**APPLICATION NO:** 21/00147/REM/ADDINF

**DESCRIPTION:** Submission of Reserved Matters for appearance, landscaping and scale pursuant to Outline Planning Permission 19/00140/OUT for erection of detached house with garage

**LOCATION:** Towsbourne Winkfield Lane Winkfield

PROPOSED GARAGE ROOF
PLAN

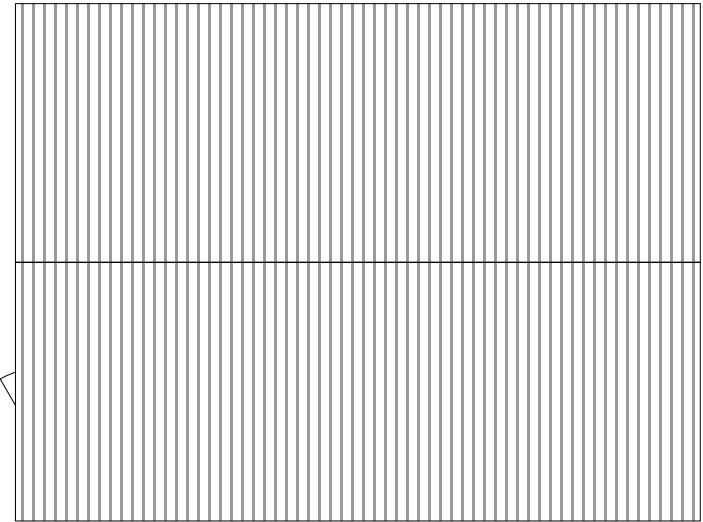
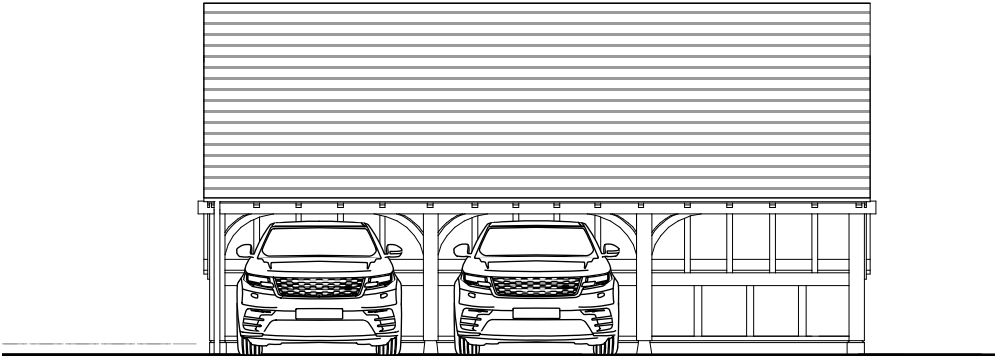
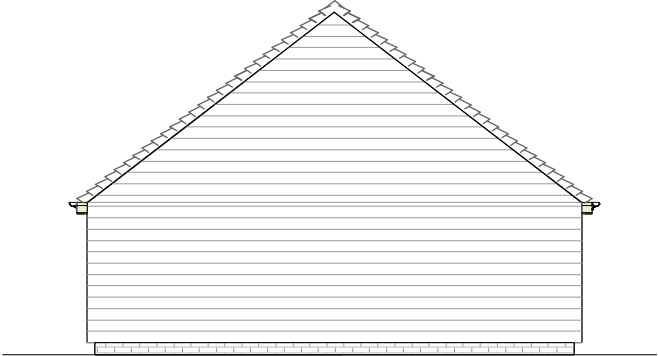
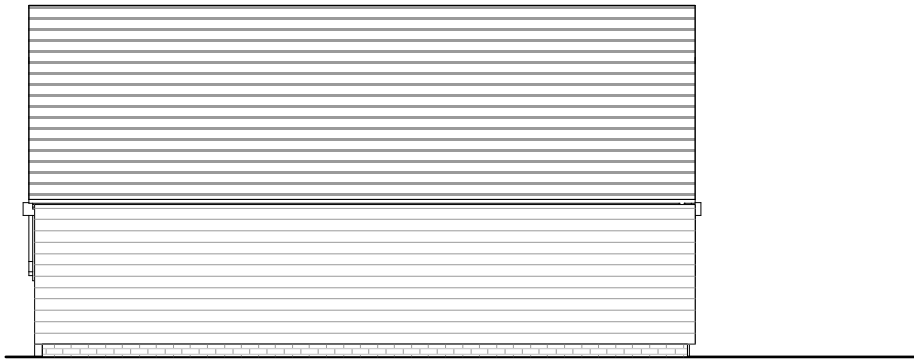
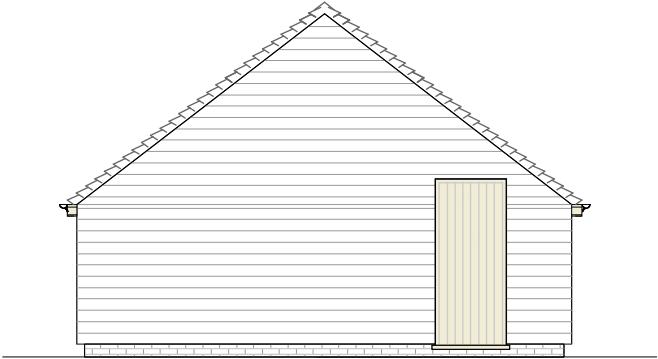
- 1 Please provide the plans, elevations and roof plan for the garage.
- 2 The roof lights appear to be missing from the roof plan, please could they be added. Could you also confirm whether the roof lights will be flush? If they protrude then please show this on the rear elevation.
